Wise Engineering
3915 Old Fairground Rd.
Angier, NC 27501
(919)894-2203

Subject: 5586 US 401 N, Fuquay Varina, NC 27526

At your request, I reviewed the proposed roof structure for a deck covering being constructed at your residence. Specifically, I analyzed a timber truss for use as the deck roof structure.

Roof over Existing Porch
Rafter Layout + Design

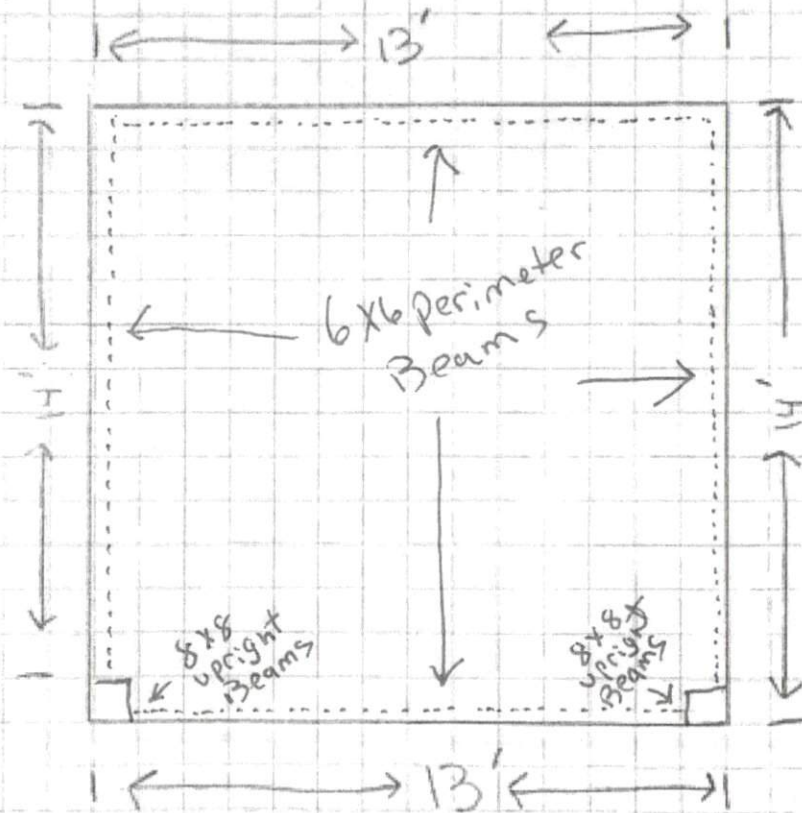
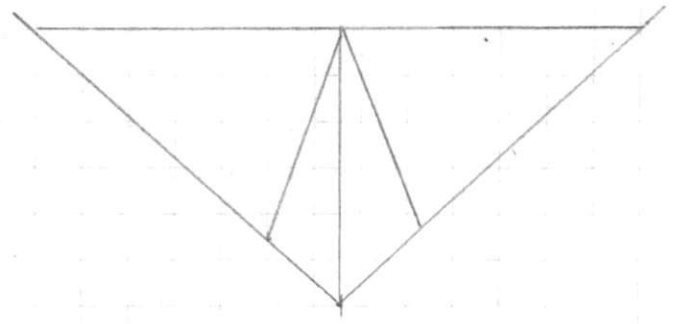
Based on my analysis, the trusses may be constructed of 4x6 sawn lumber (SYP) as described below. The king post truss should consist of a middle "king" post, 2 top chord (or rafter members), and a single bottom chord. The king post trusses should be constructed of 4x6's fastened together with TimberLok screws (4 per connection minimum). The trusses should be spaced 3'-0" on center and span approximately 13 ft. The top chord to bottom chord connections as well as the king post to top and bottom chord connections should be supplemented with "Strap Ties" (or plates) such as Simpson Strong-Tie PS418PC or equivalent. In addition, as an option, the truss may have struts if desired, but are not needed structurally. The actual roof covering can be supported over these trusses by use of purlins and 2x4 rafter plates.

Additionally, the 6x6 beam (truss supports) located on each side of the roof structure should span a maximum of 9' between supports. 6x6 corner braces may be used to reduce the actual span between post.
